CITY OF ALBUQUERQUE

April 25, 2017

**Re: The Center At Animal Humane
615 Wyoming Blvd. SE
Traffic Circulation Layout
Architect's Stamp 4-21-17 (L19D058)**

# SITE PLAN

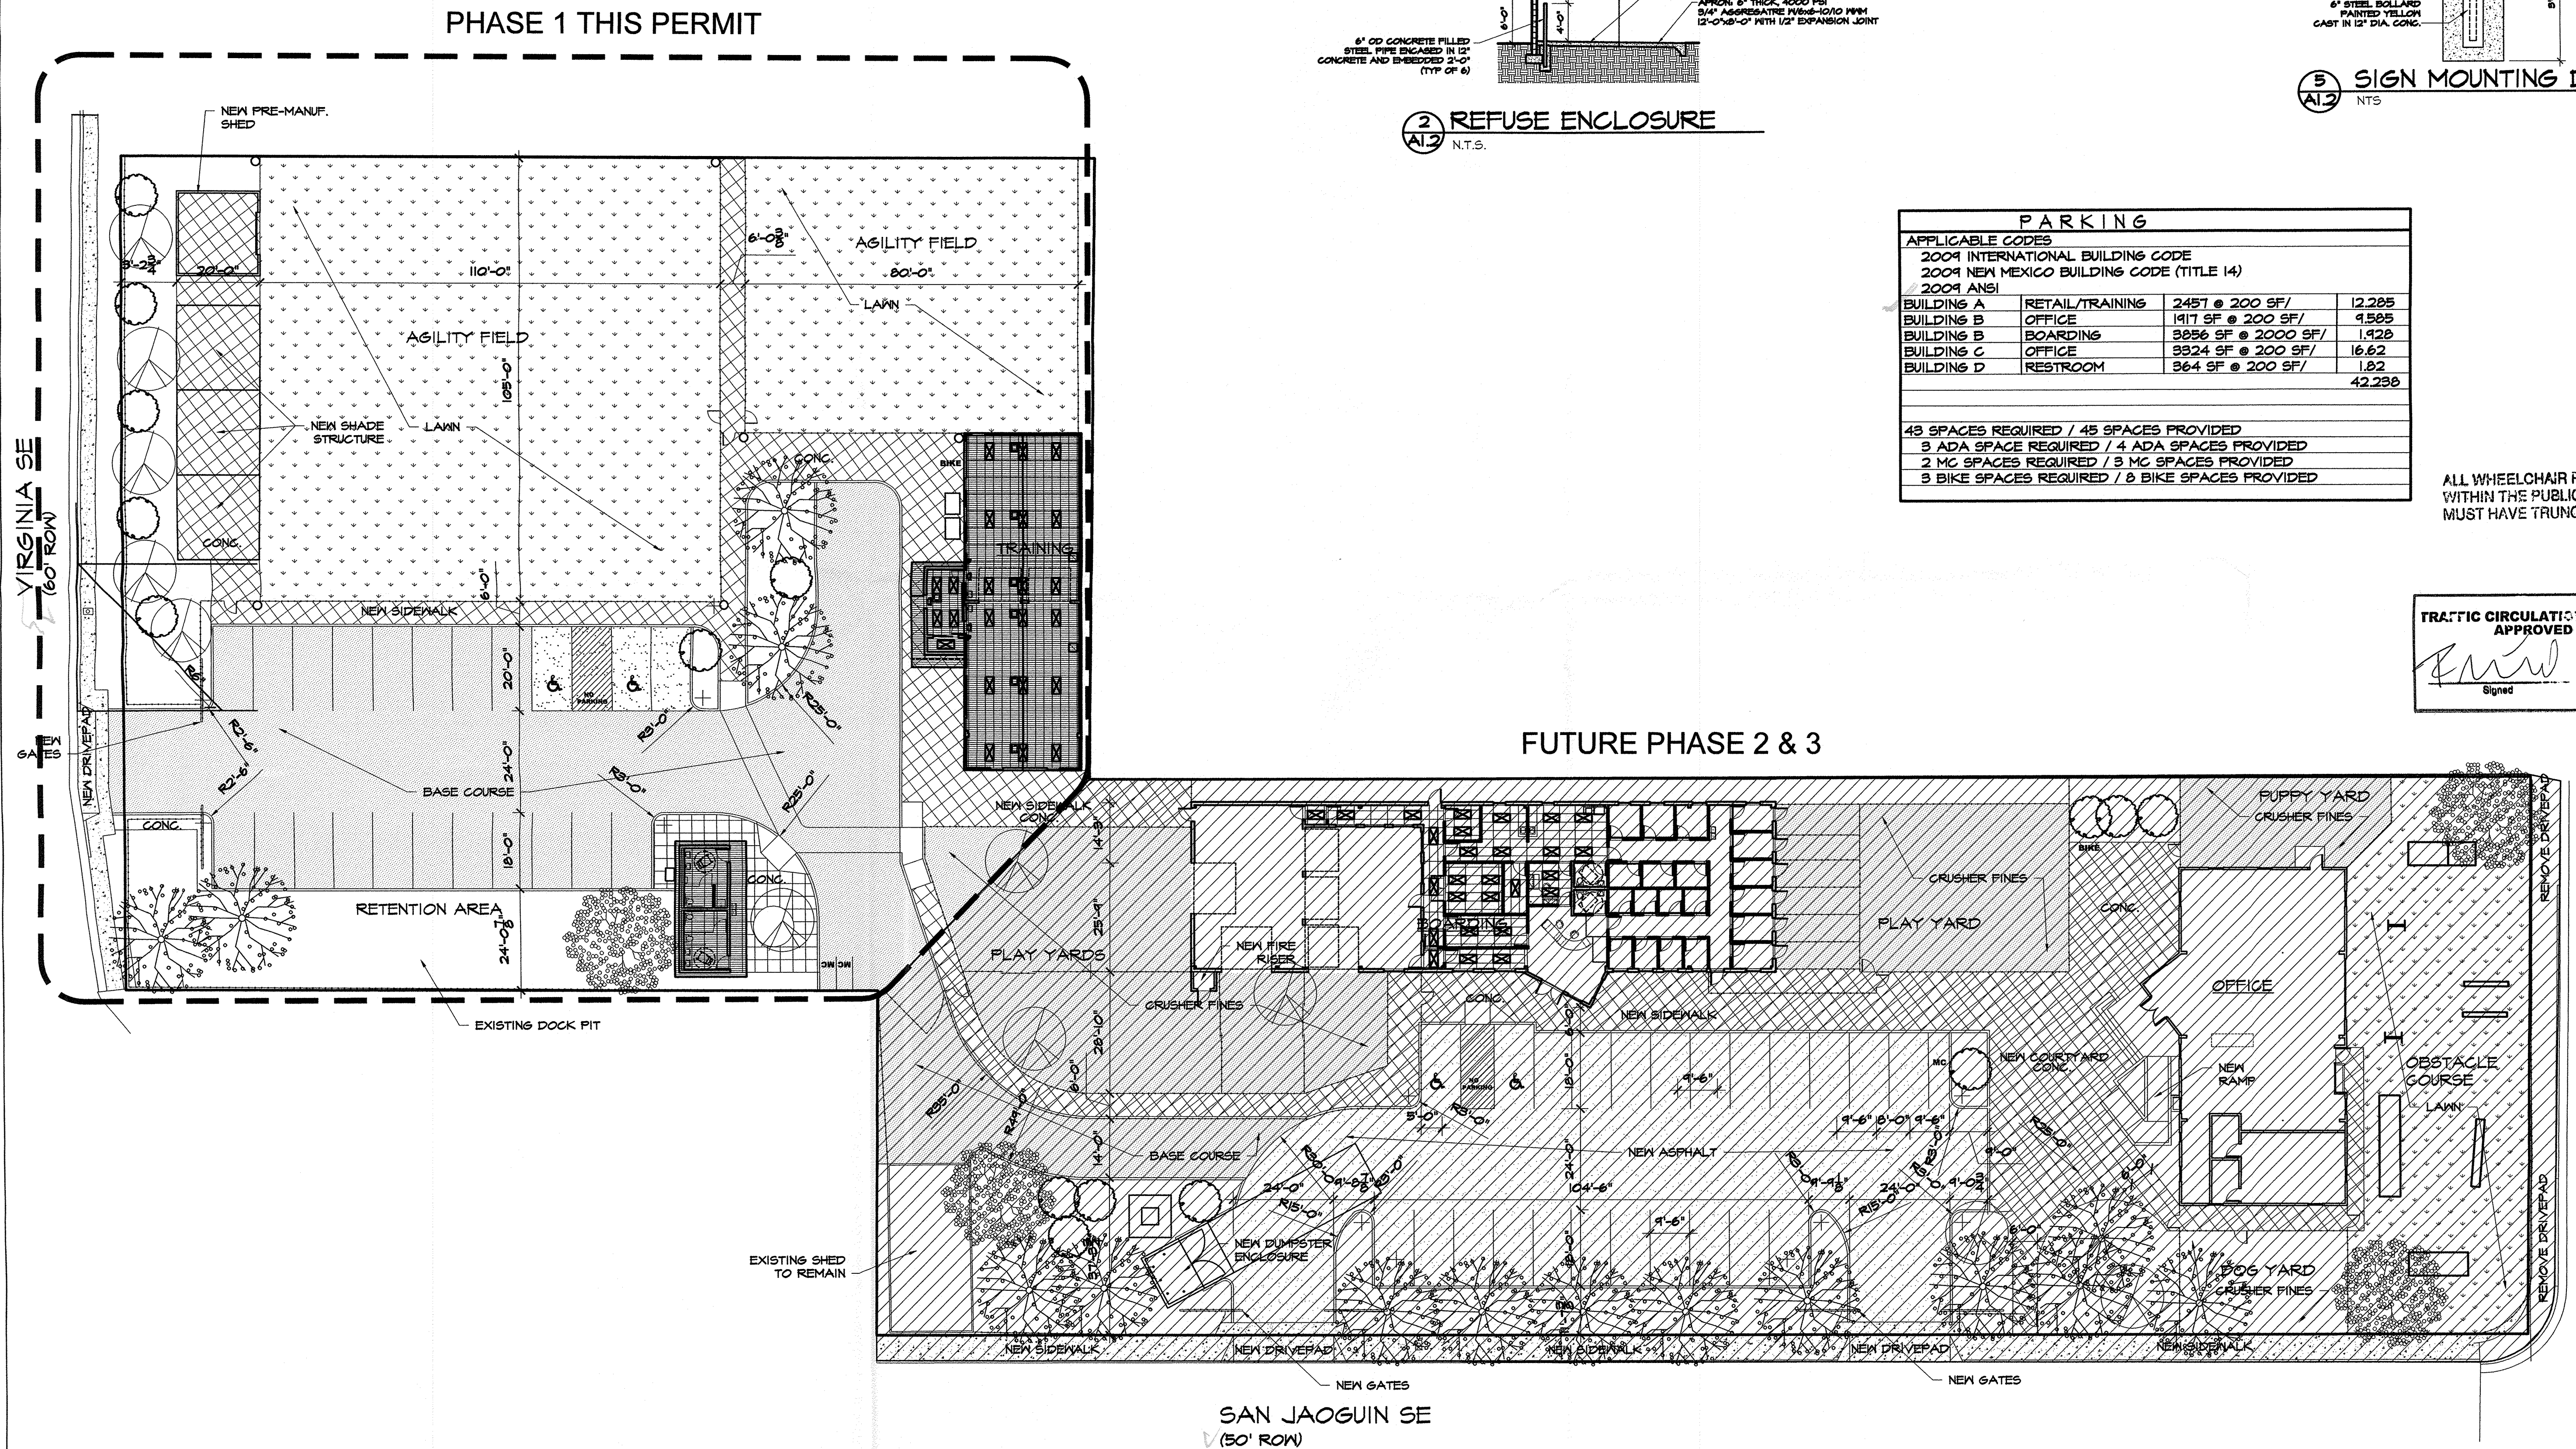
1. Please clearly identify the property line. Any ADA path outside of the Right Of Way, at both driveway entrances, need sidewalk easements before release of CO.
2. Provide a detail for the new gates including how tall they are and if they will interfere with clear sight?
3. Clarify location of bike rack.
4. Provide an electronic copy of corrected plan to PLNDRS@cabq.gov
